KIRKLEES METROPOLITAN COUNCIL INVESTMENT & REGENERATION SERVICE

DELEGATED DECISION TO DETERMINE PLANNING APPLICATIONS

Reference No:	2024/62/92754/E
Site Address:	Hope House, 62, Turnsteads Avenue, Cleckheaton, BD19 3AL
Description:	Erection of first floor side extension and associated alterations
Recommending Officer:	Faiza Bano

HOUSEHOLDER DELEGATED REPORT

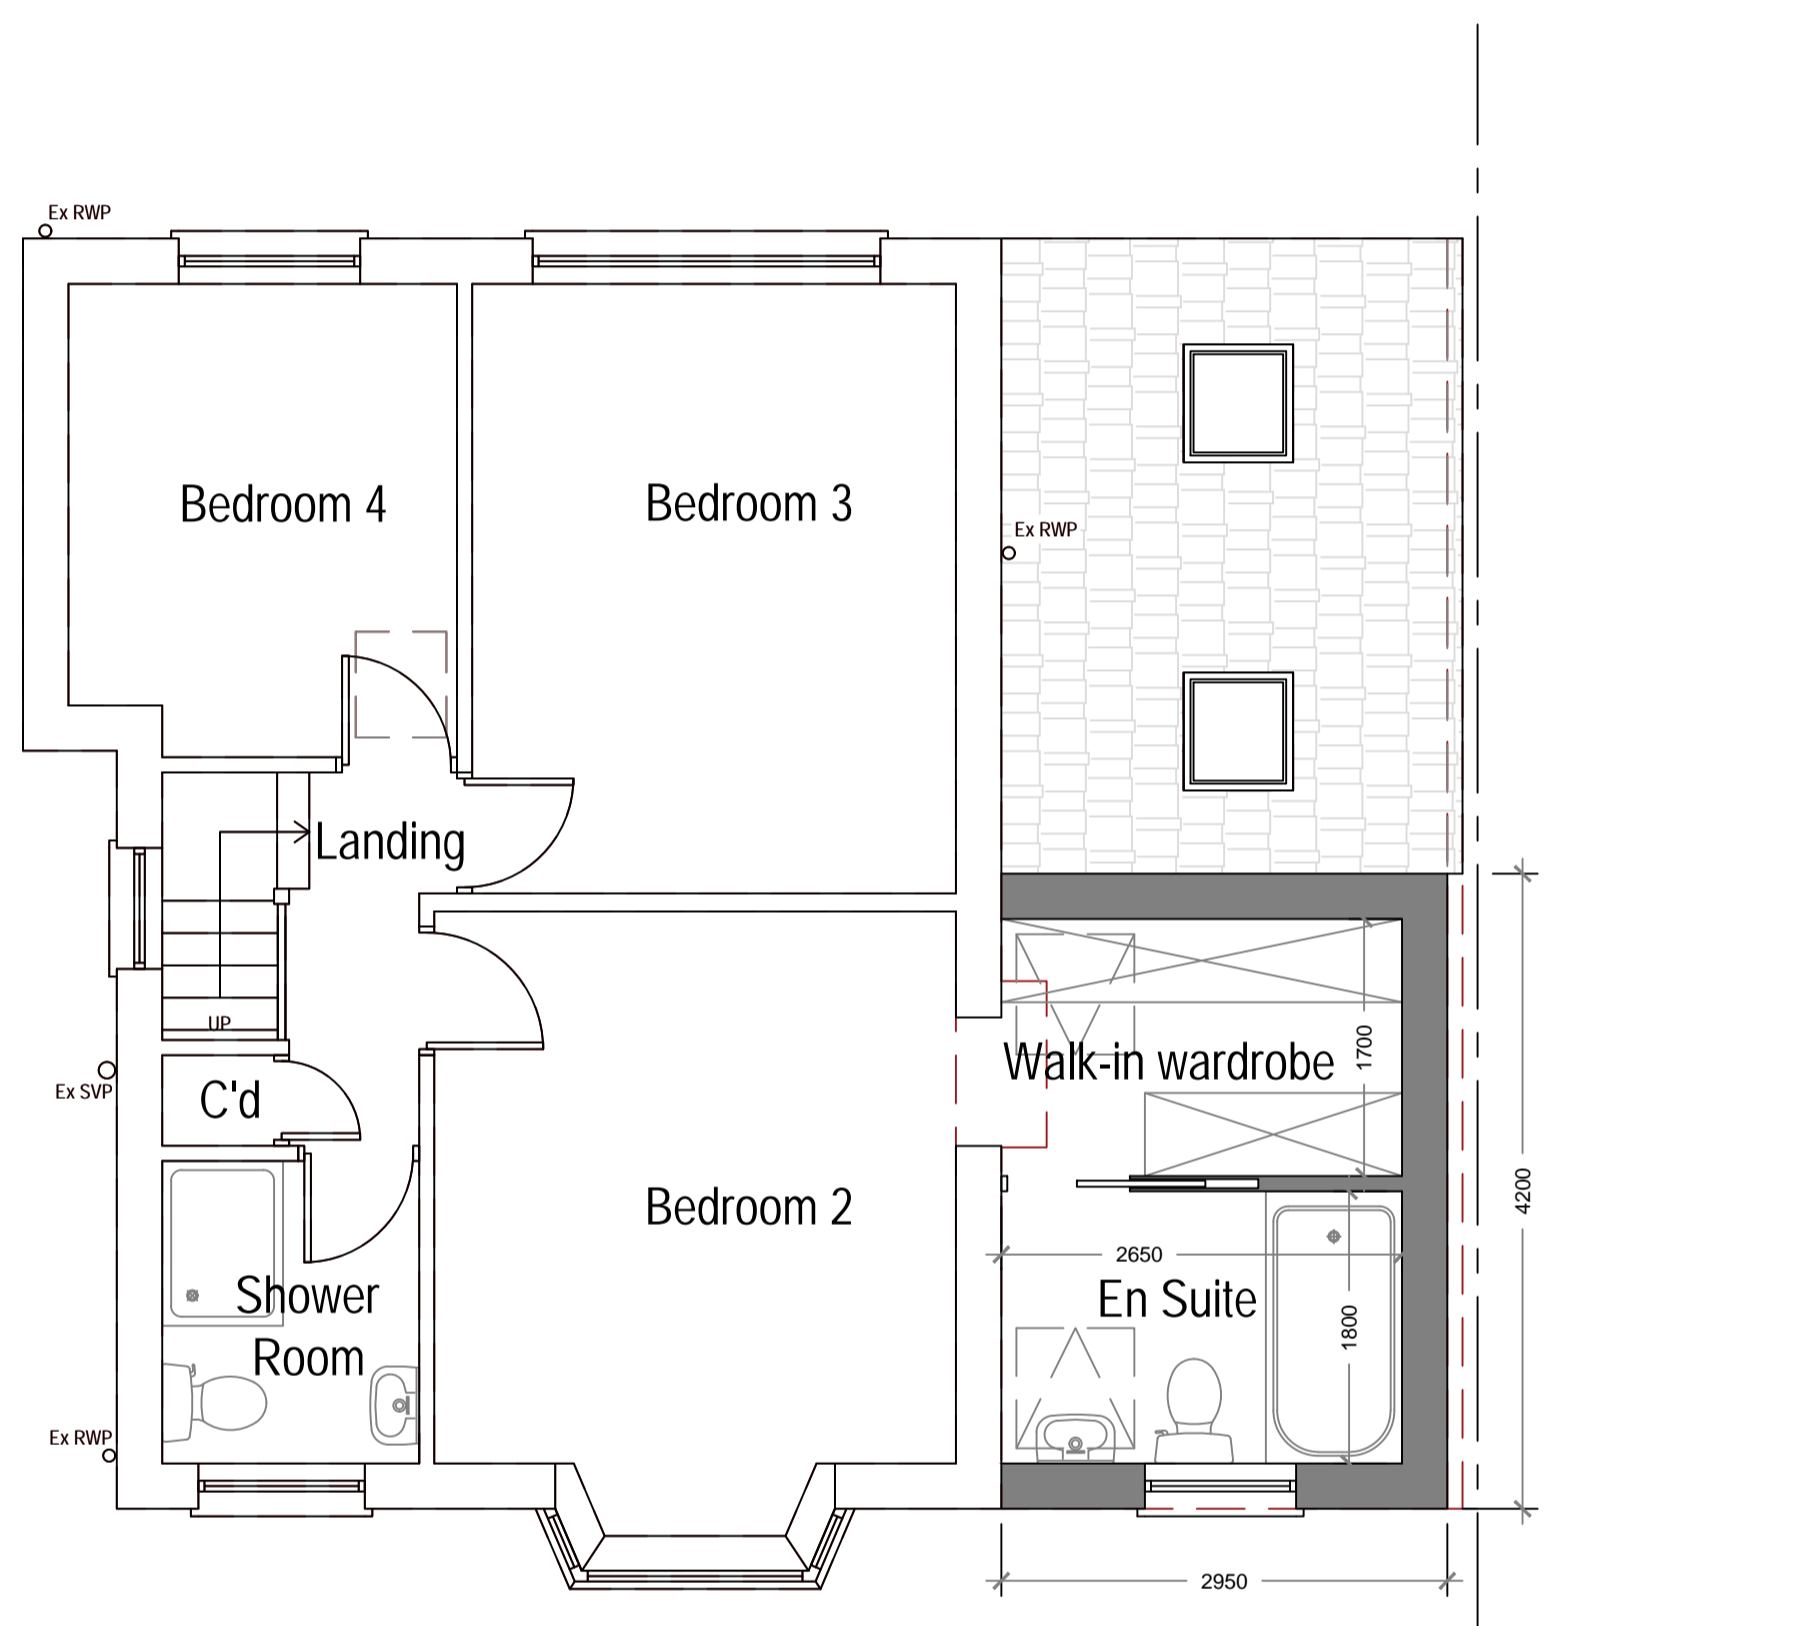
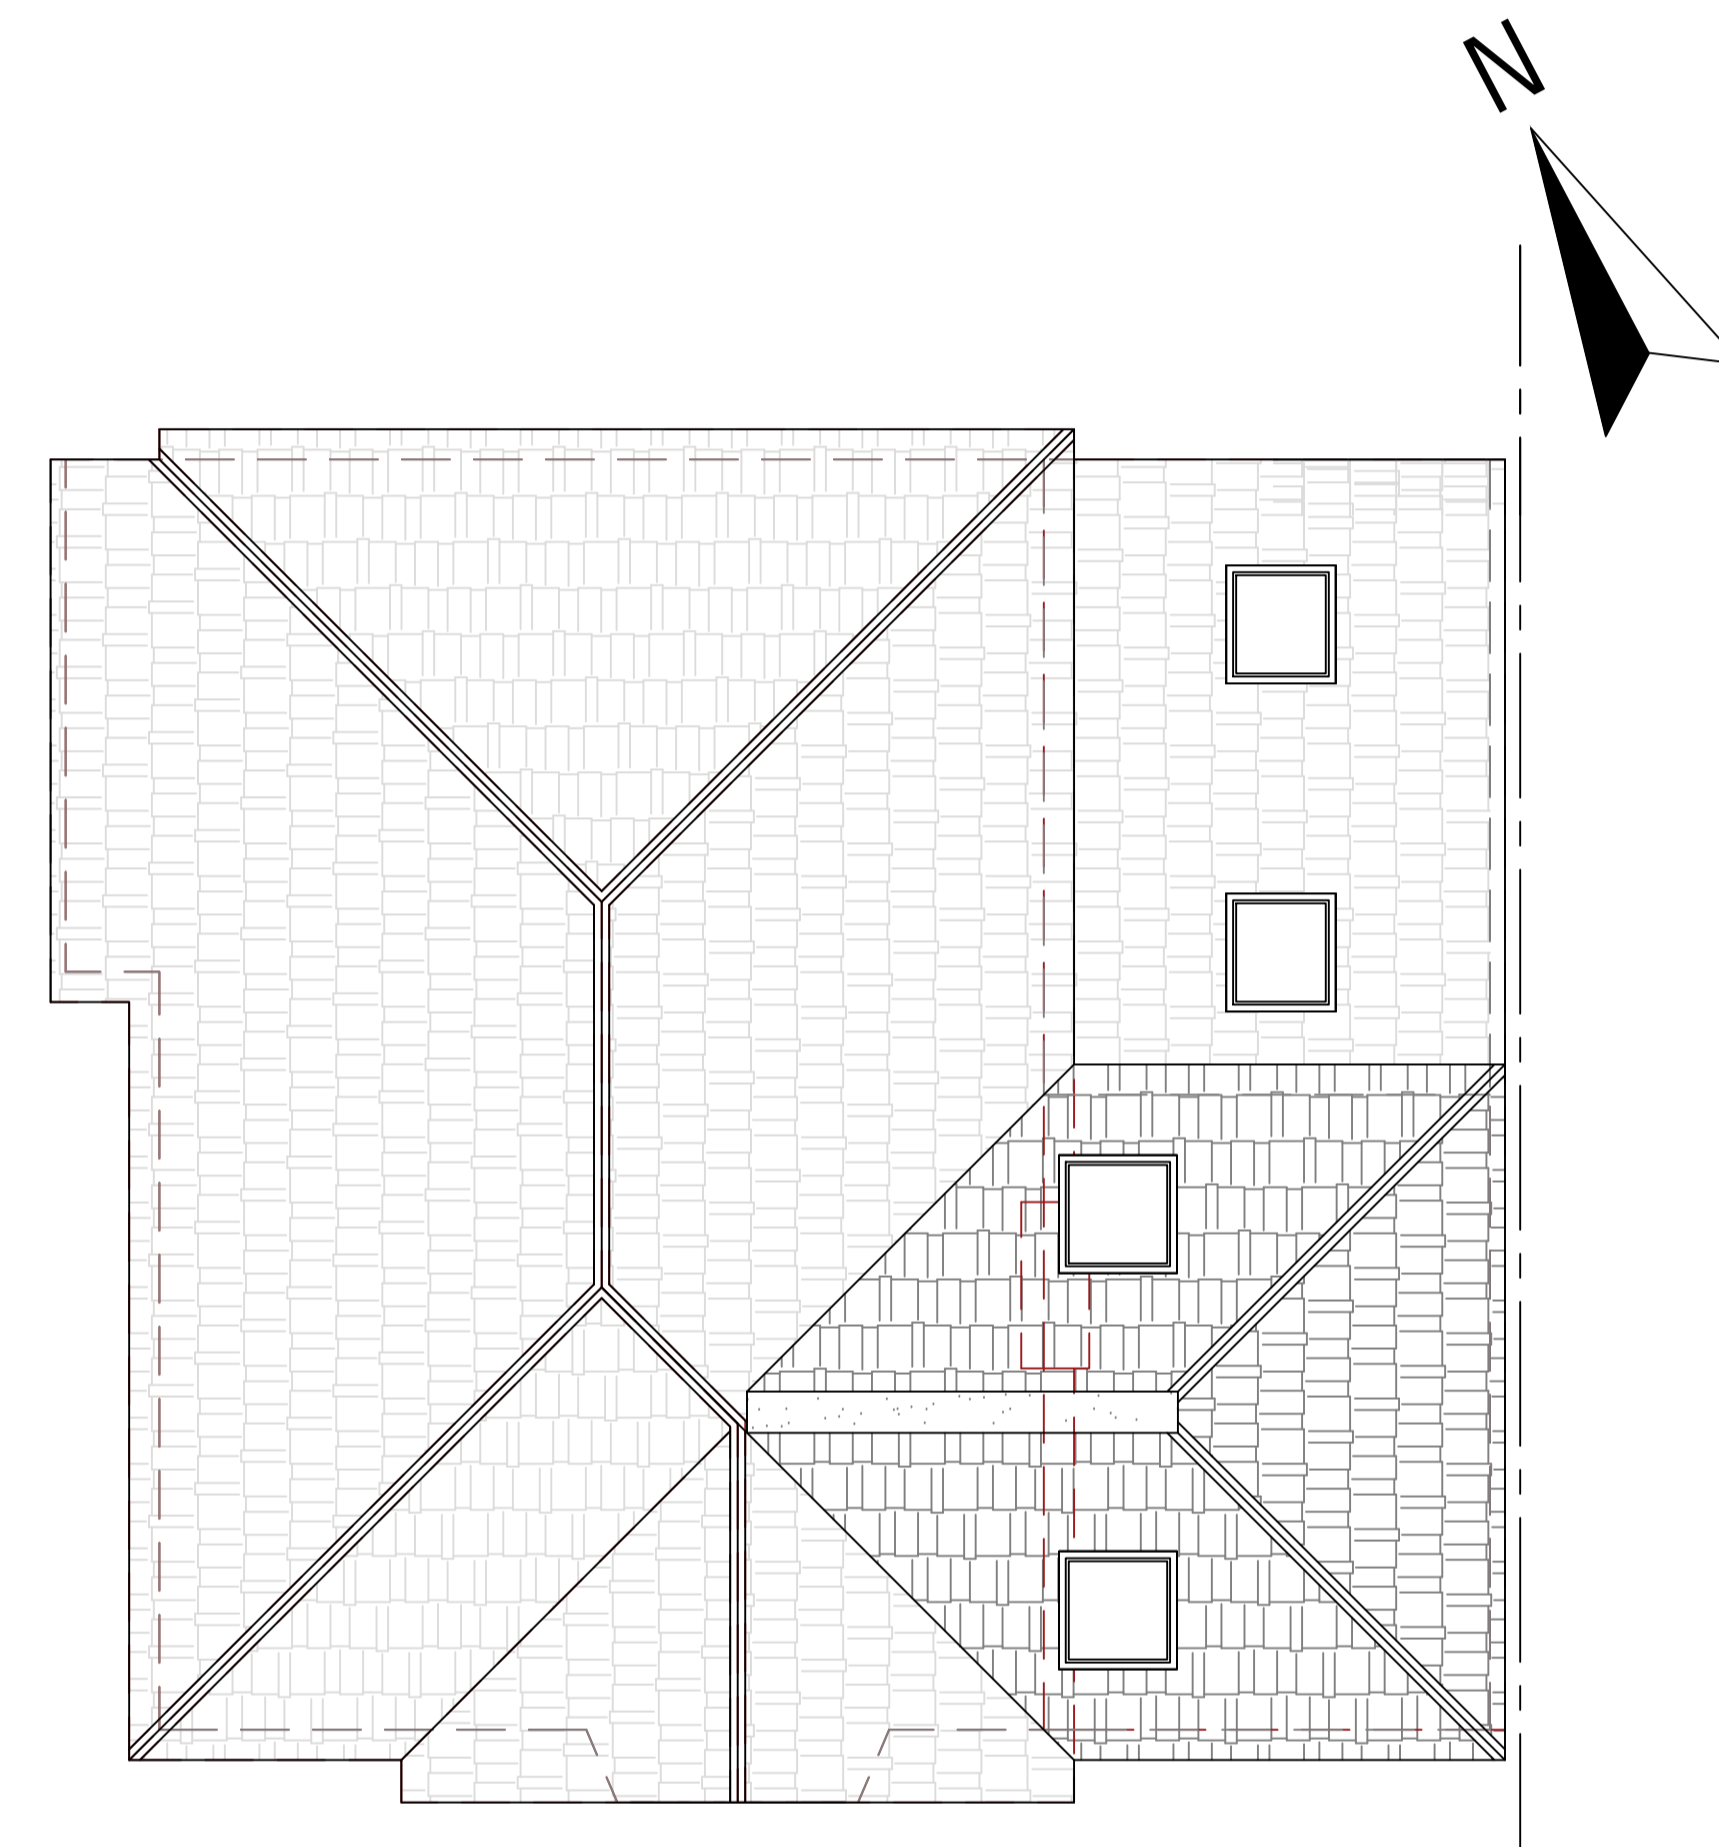
be set back at least 500mm from the front wall of the house		The proposal is not set back from the front wall of the house; however, it is set back from the principal element across the front. As a result, the proposed extension would fit the street scene and is deemed acceptable.
---	--	--

Site	62 Turnsteads Avenue, Cleckheaton BD19 3AL	Date	19.09.2024
		Sheet	24-1618 D05 REV 01
		Job	New Extension
Title Number	WYK662095	Scale	1:50 @A1, 1:100 @A3
		Title	As Shown

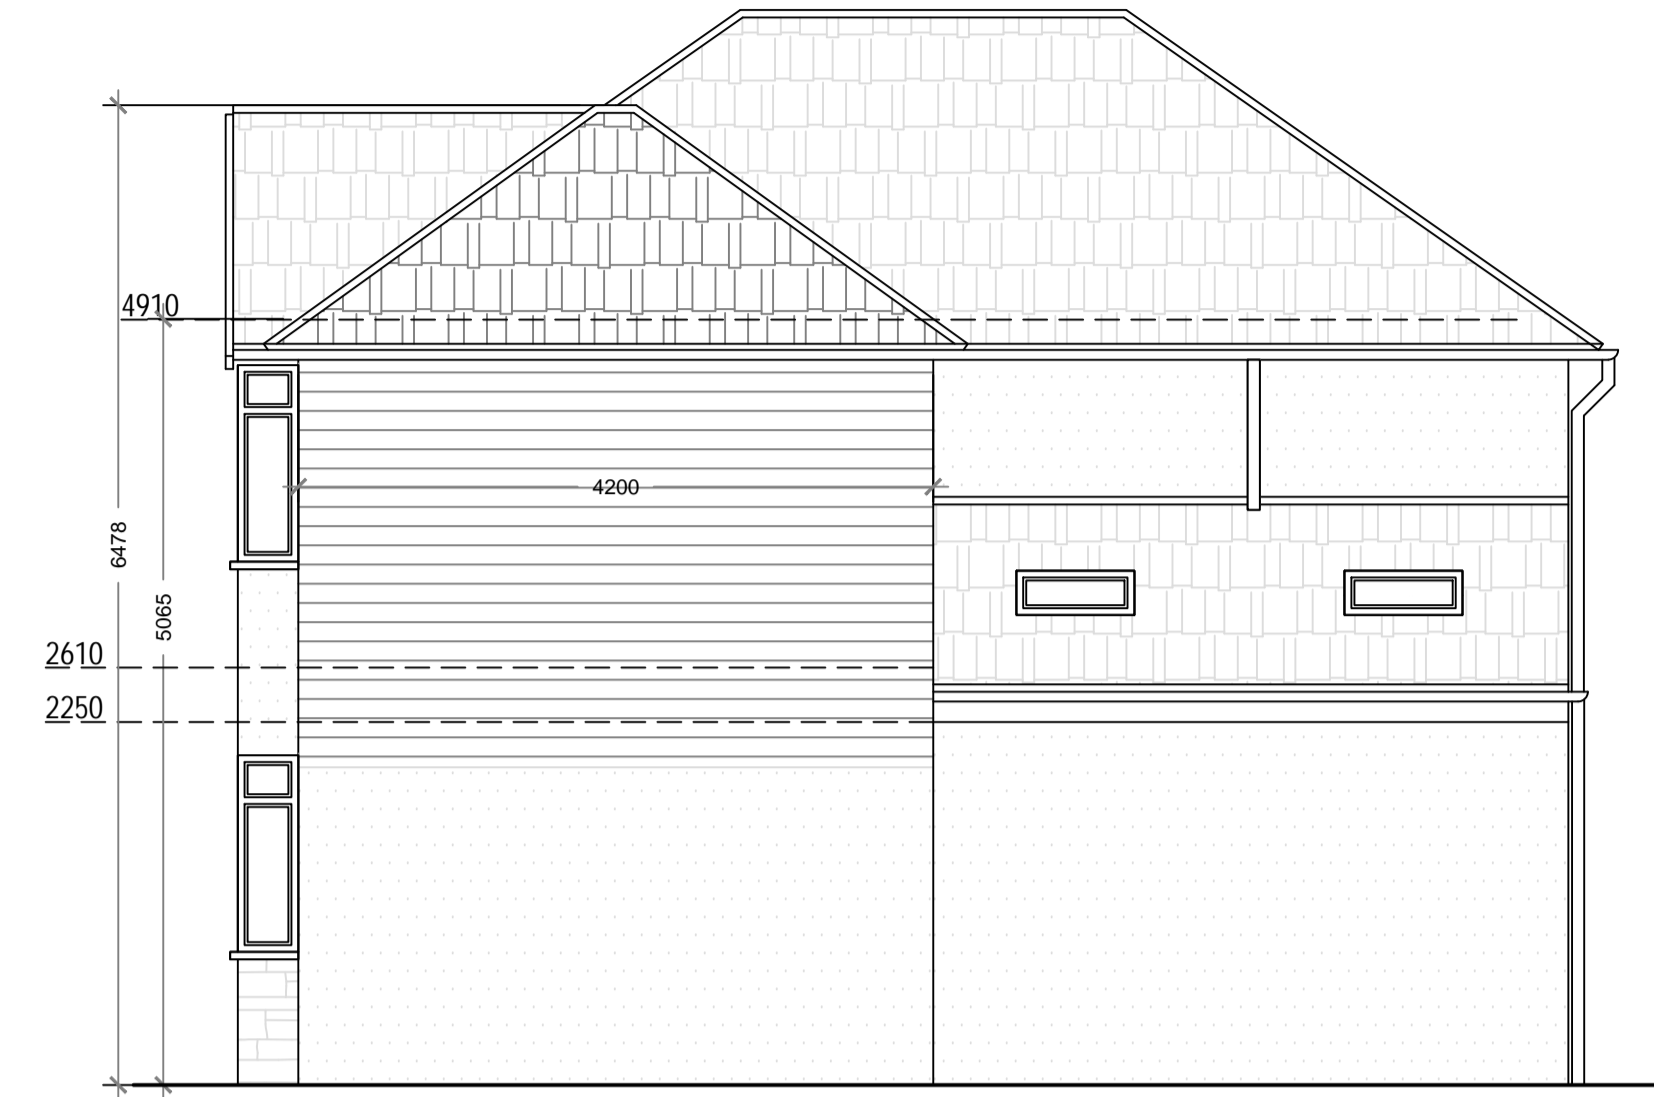
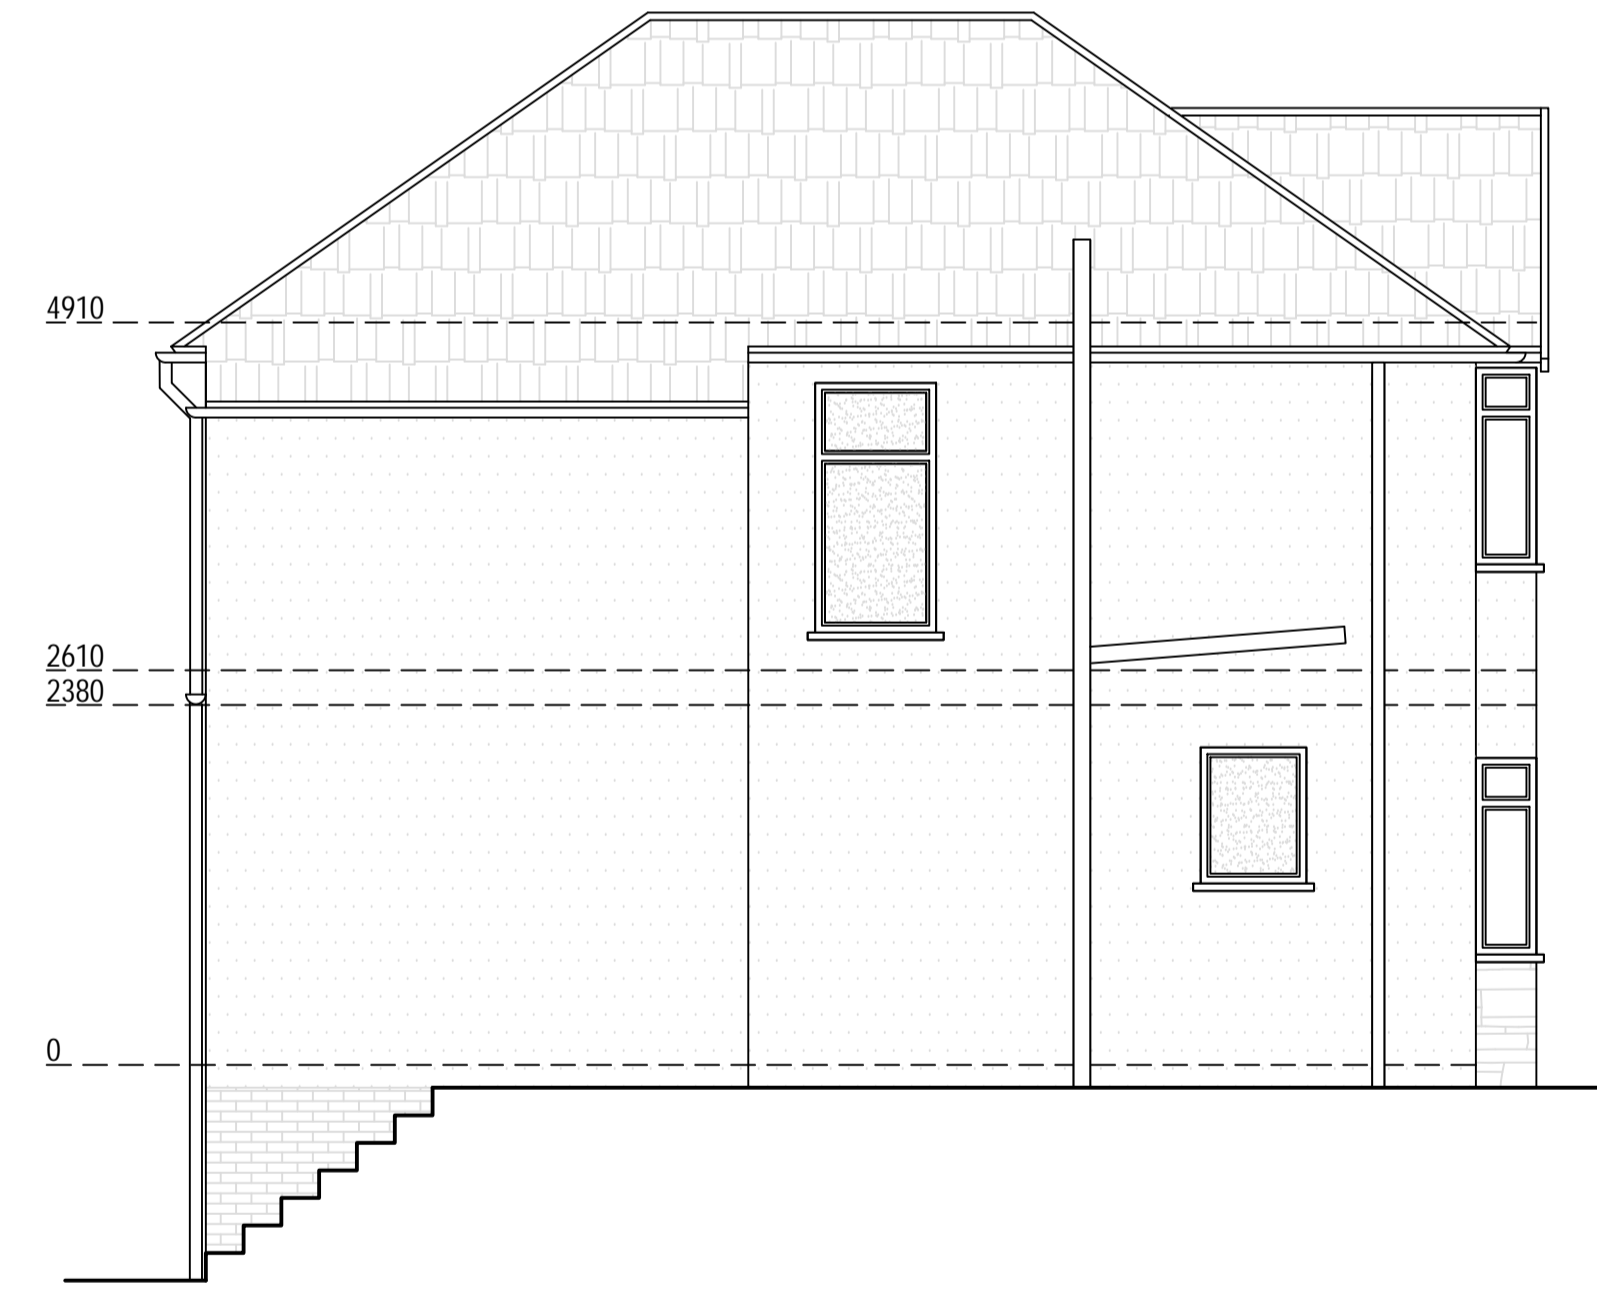
Positioning windows to minimise or avoid any potential overlook into neighbouring gardens	The proposed window and rooflight along the front elevation will be facing the front amenity area of the application site; there is a proposed rooflight in the extension along the rear elevation – with it facing the rear amenity area of the site, it minimises concerns regarding overlooking as the proposed rooms are considered non-habitable.	
Two storey side extensions should:		
Not take up all or most of the space to the side of a house	Yes – the first floor would be small in size and remain subservient to the existing building on site. The width of this extension would be limited the width of the existing single storey side section. It is considered that the scale of development as proposed is acceptable from a visual amenity perspective.	
maintain a 1 metre gap to the side boundary to ensure the building is not too close to a neighbouring property		The proposal would not impact upon access to the side given the existing building is built up, at ground floor level, to the shared boundary.

Relevant key design principle (KDP) of the SPD, Policy in the Kirklees Local Plan and the NPPF	Further comments	✓ / X / N/A
Impact on the Local character and street scene	• KDP1 of the SPD • Policy LP24 Design (a) and (c) of the KLP • Chapter 12 NPPF	The dwelling is located in a residential area, that includes similar extensions to that which is proposed. Within the application form the proposed material for	✓

the walls is timber cladding. The locality is predominantly pebble dash or stone / brick materials. There is no use of timber cladding upon properties within the street. In this case it is considered its use would not be in keeping with the character / appearance of the locality and a condition requiring matching materials is therefore considered to be necessary and worded to state this requirement is notwithstanding the submitted details. Subject to condition relating to materials the proposal is considered acceptable in this regard.	
Impact on original house	• KDP2 of the SPD • Policy LP24 Design (c) and (d) of the KLP • Chapter 12 of the NPPF	The extension is not considered to be disproportionate in relation to the original property, ensuring there is no significant impact to the original property.	✓
Height, scale and massing	• KDP 1 and 2 of the SPD • Policy LP24 Design (a), (c) and (d) of the KLP • Chapter 12 of the NPPF	Two-storey in height and lies flush to the original building, appearing proportionate to the host property.	✓

3. Notwithstanding the plans and application form submitted, the external walls and roofing materials of the extension hereby approved shall in all respects match those used in the construction of the existing building and be retained thereafter.
